**SUBJECT: Monument Academy – Site Development Plan  
Response to County Review Comments  
PPR-19-009**

In conjunction with our Site Development Plan re-submittal, this letter provides responses to the PCD Project Manager Comments posted on March 26, 2019 and the Memorandum from PCD-Engineering dated April 8, 2019. These review comments are specifically addressed as follows **(Applicant responses are annotated in bold / red / parenthesis following each County comment):**

ENLARGED DETENTION POND M3 PLAN

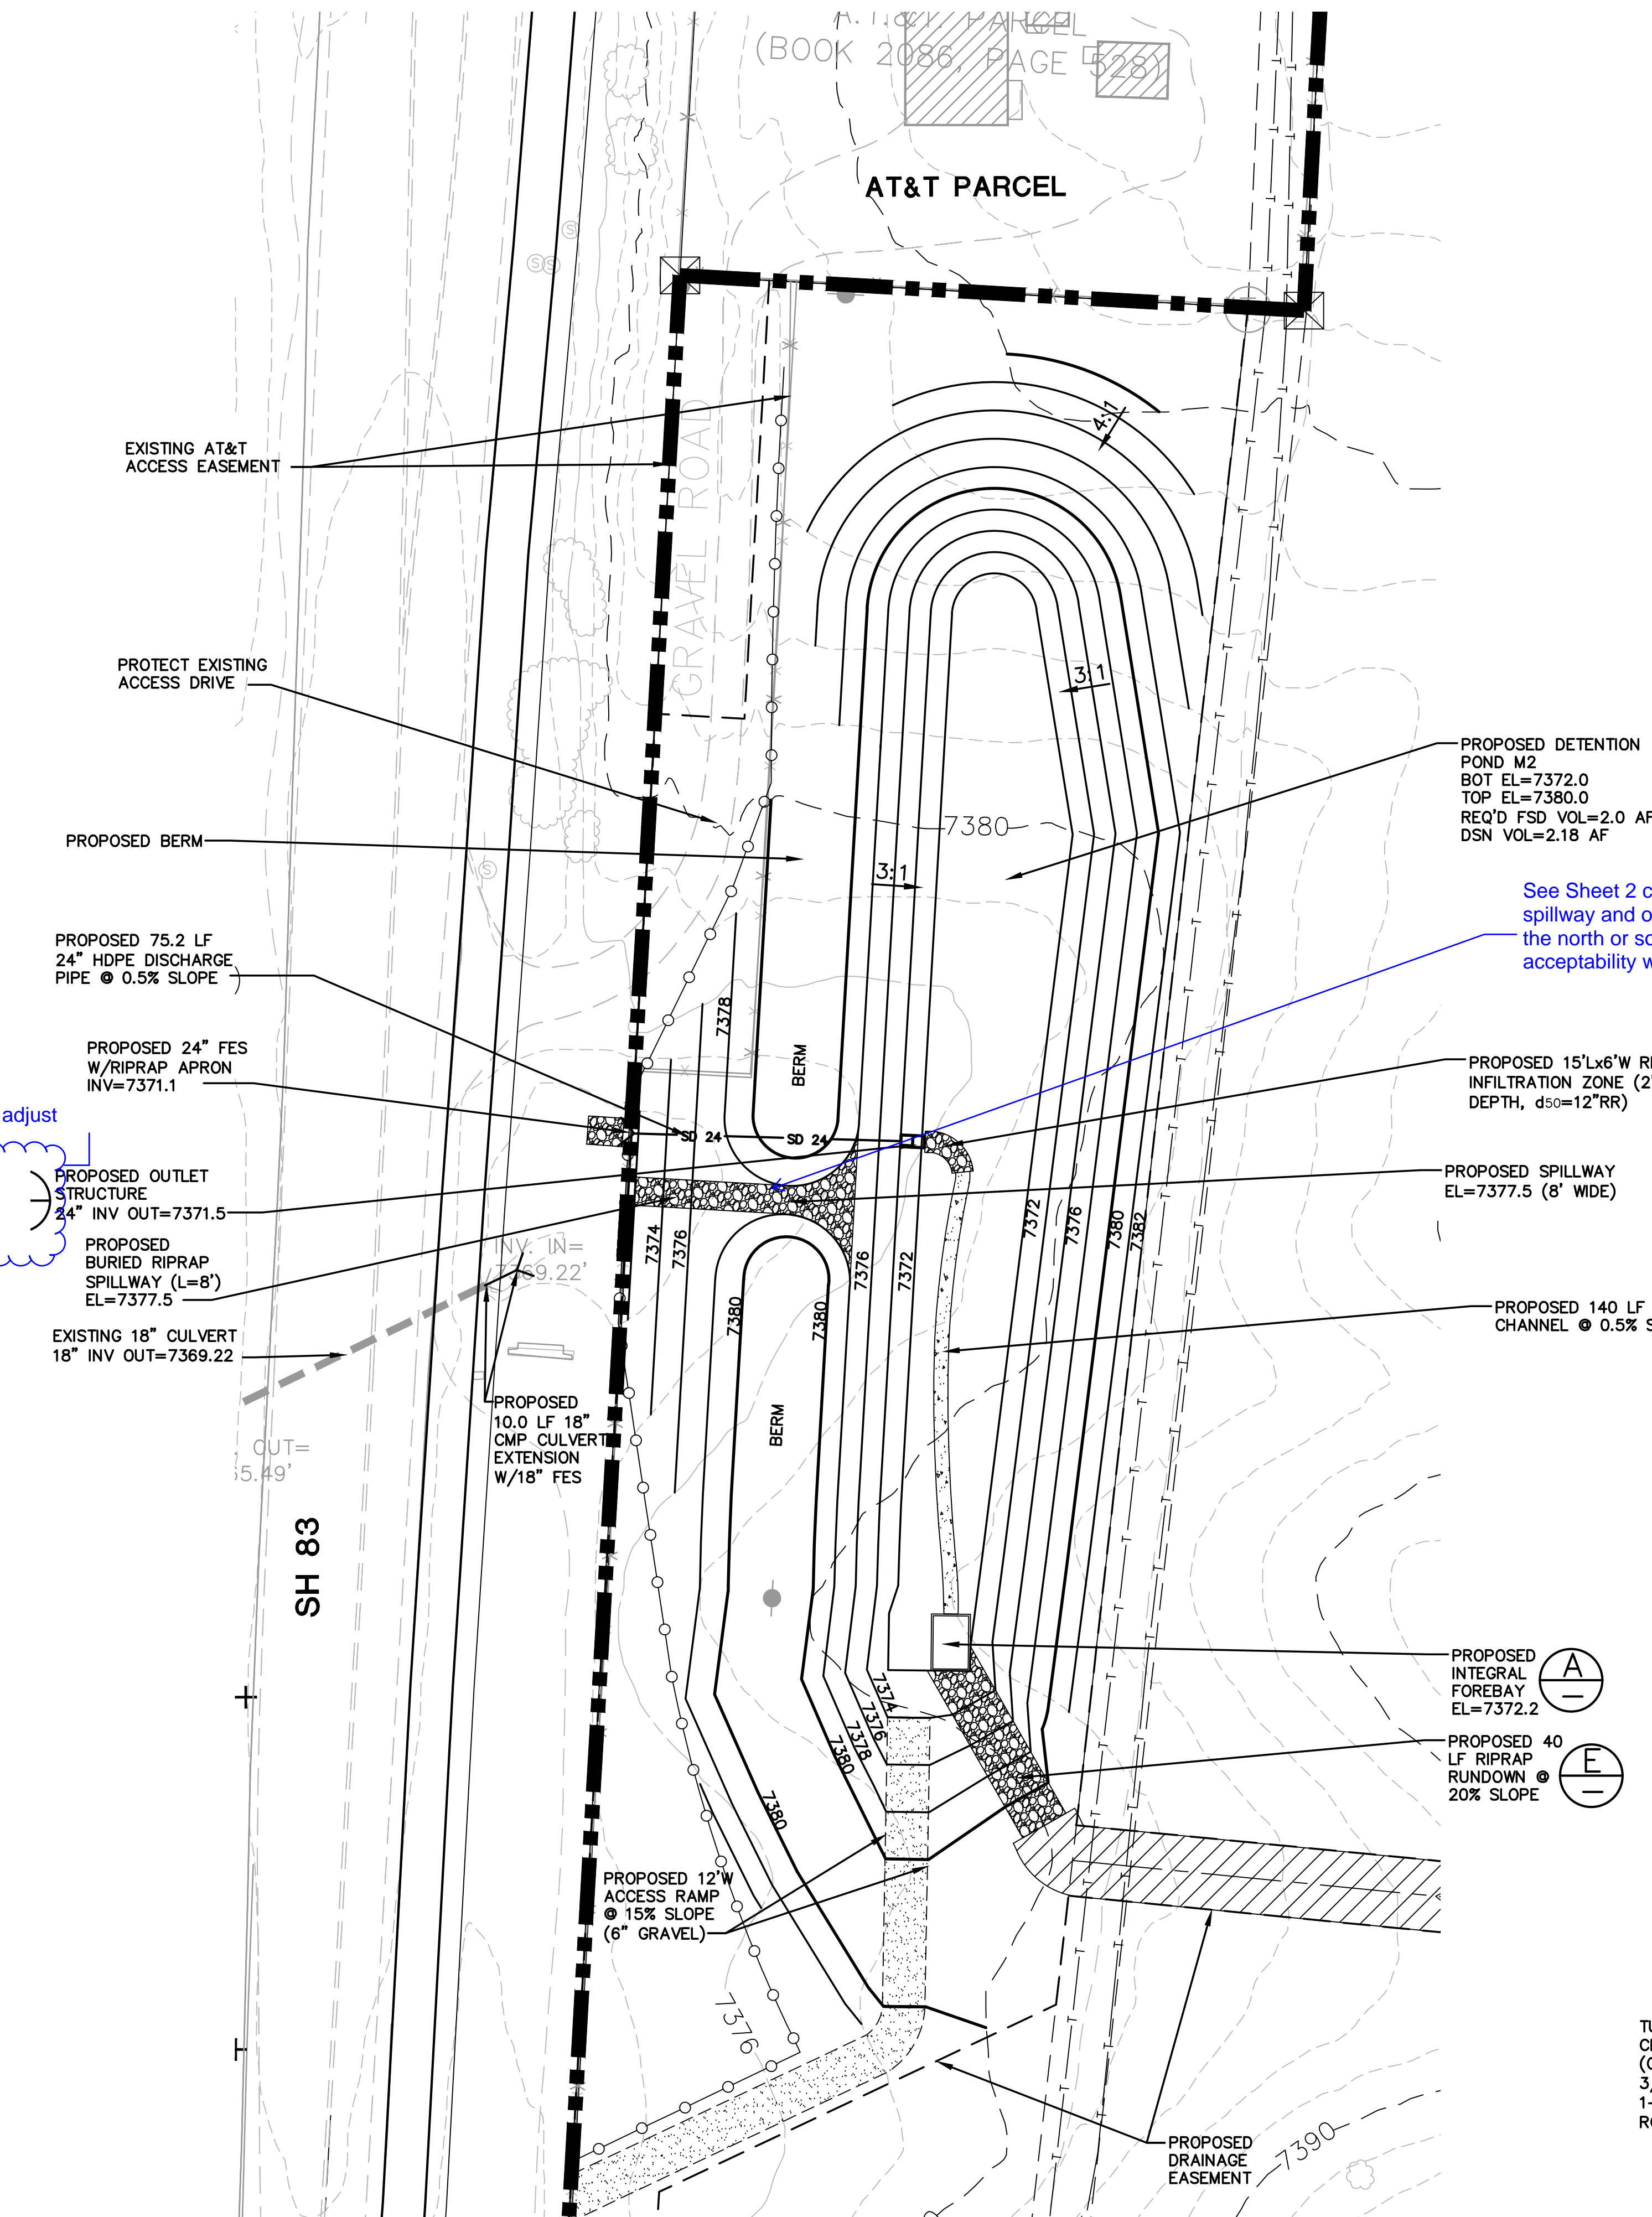
5. Provide complete detention pond details, including emergency spillway width, length and horizontal and vertical control points (as well as any other details required by the State). **(Detention pond details are provided on Sh. C3.1-C3.3)**

C2.0

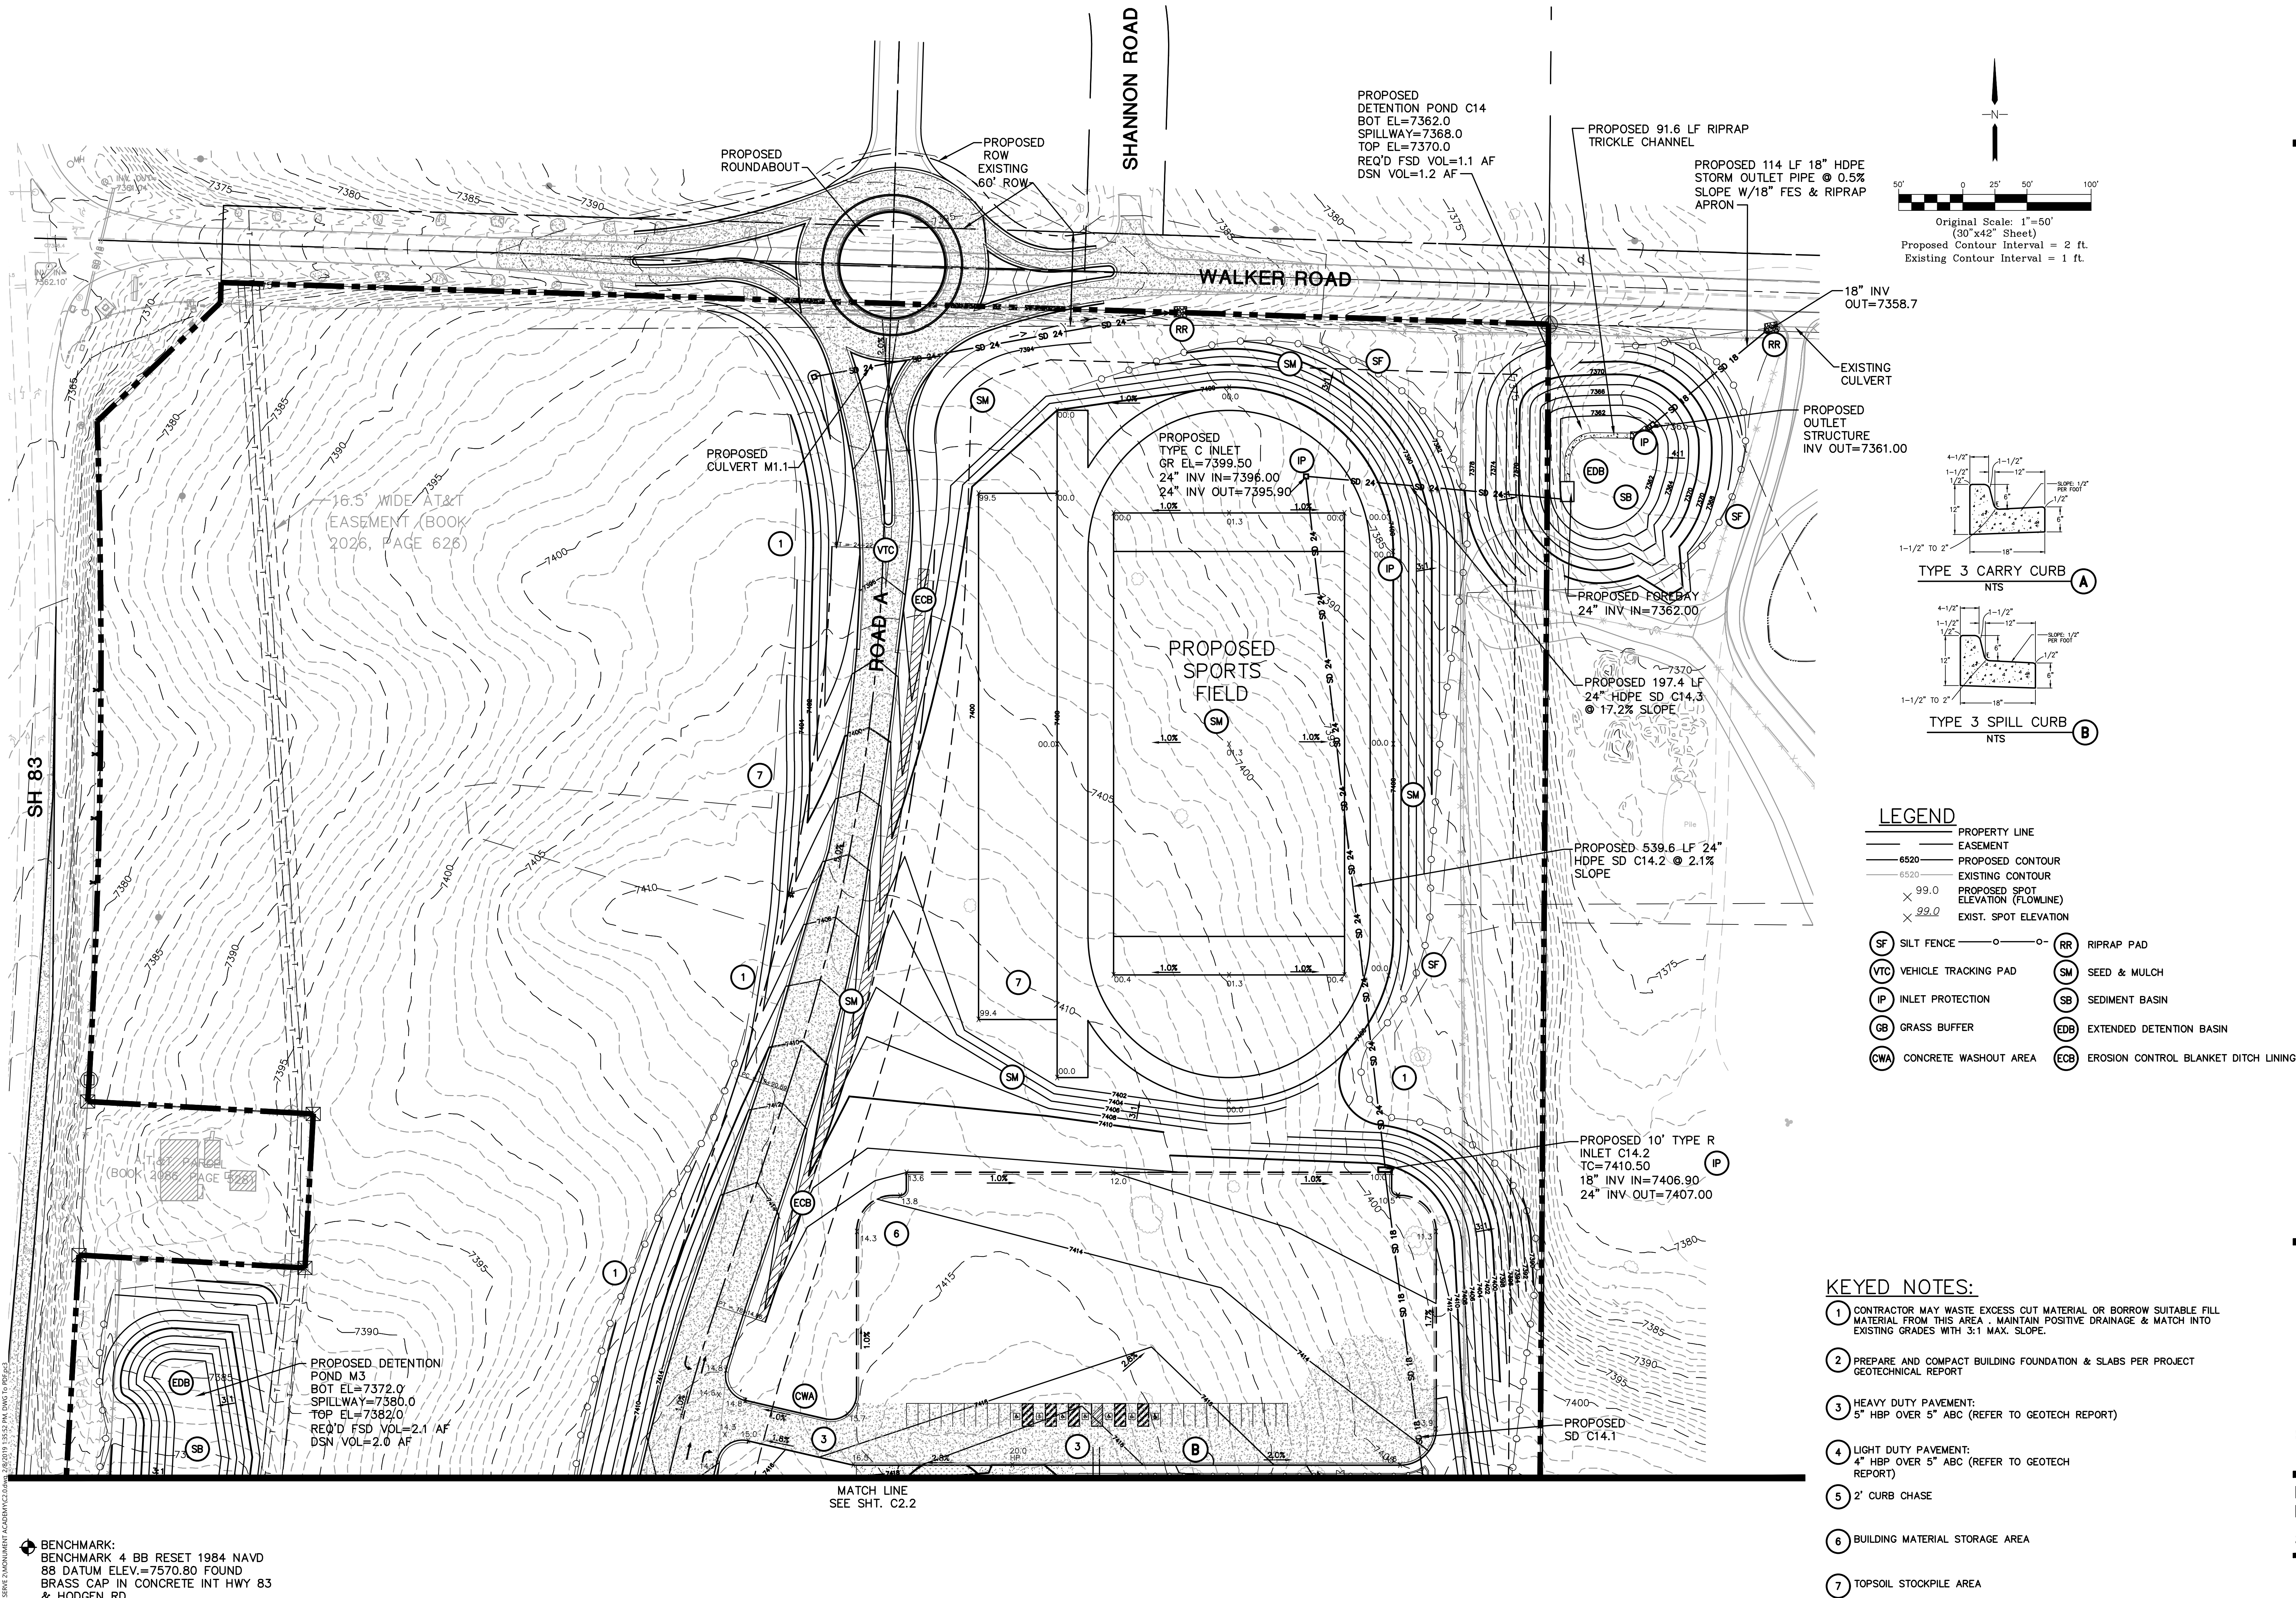
6. Provide a master construction phasing plan/map addressing the following:
  - a. Initial access for school construction; **(Noted on Sh. C2.0)**
  - b. Timing of right-of-way acquisition for roundabout and Shannon Road (will that property owner be a co-applicant or sell developer the property?); **(No longer applicable)**
